Planning consultation: 3/2024/0177 - Proposed construction of an earth banked slurry lagoon and associated landscaping
Location: Higher Greenhead Farm Gisburn Road Sawley BB7 4LQ

Insufficient Information Provided

SCAIL ASSESSMENT – HIGHER GREENHEAD SLURRY LAGOON

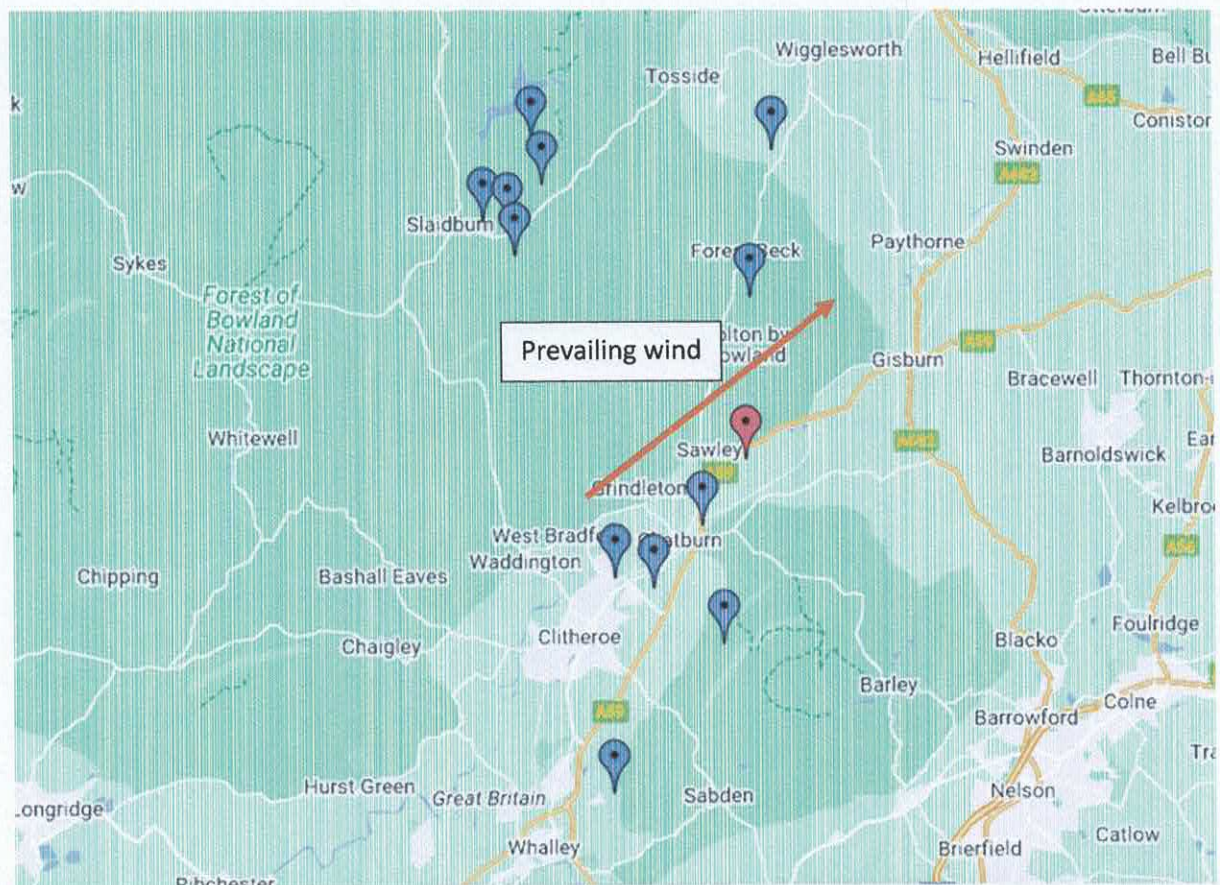
We advise that the SCAIL assessment is re-run as results of the SCAIL assessment only discusses Clitheroe Knoll Reefs Site of Special Scientific Interest (SSSI) on PDF page 4 of 4. Please note, Natural England applies a 10km screening distance for European designated sites which are vulnerable to air quality changes.

In addition, we have not been sent both the Input and Output SCAIL files (including the CSV file) which we require for the list of designated sites screened during the SCAIL assessment. More information can be found in **Annex A**.

No assessment has been provided of the potential impacts the proposal will have on Langcliff Cross Meadow Site of Special Scientific Interest (SSSI), Bell Sykes Meadows SSSI and New Ing Meadow SSSI.

We advise that the SCAIL assessment is re-run to assess potential impacts of the proposal on these designated sites.
